Transport  
for NSW

**Notice of Exhibition - New Grafton Correctional Centre Stage 2 – Design,  
Construction and Operation (SSD 8368)**

Thank you for your recent correspondence requesting Transport for NSW (TfNSW) provides comment on the Environmental Impact Statement (EIS) for the development mentioned above.

Figure 3.2 – Entry Road Layout and Routes

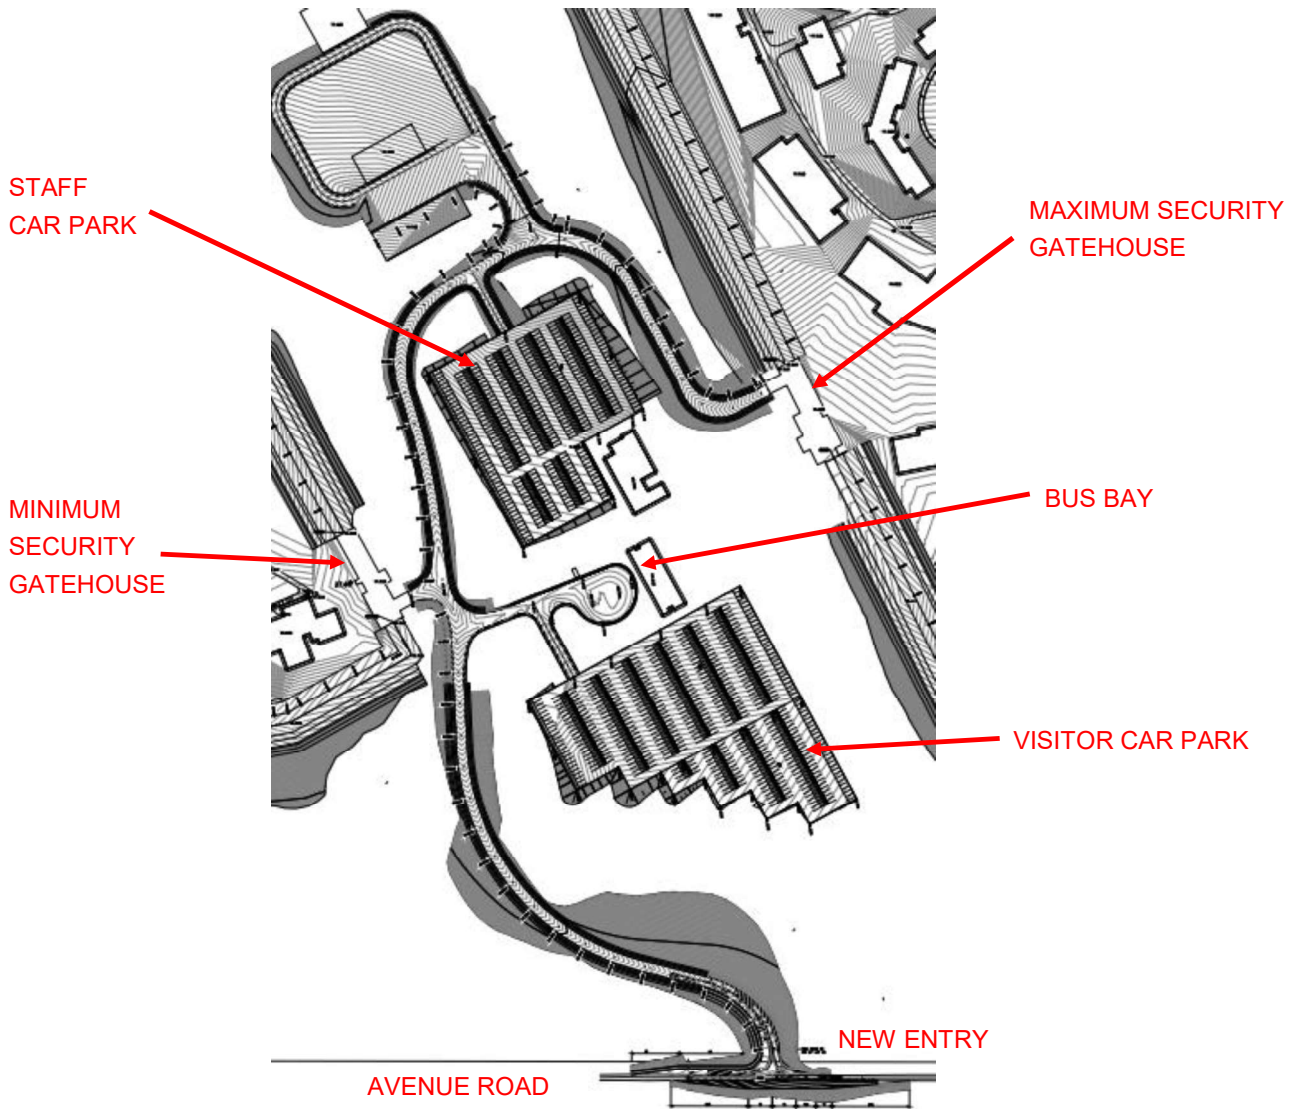
TfNSW notes that Section 3.9 of the *Transport & Accessibility Report* states that provisions will be made onsite to accommodate bus services. Whilst TfNSW understands that the access road is 'bus capable', we require further detail regarding the pick-up/drop-off area (at **Attachment A**), to ensure there is adequate swept path for the safe movement of buses within the site.

**Attachment A:** Bus pick-up/drop-off area; further detail required.
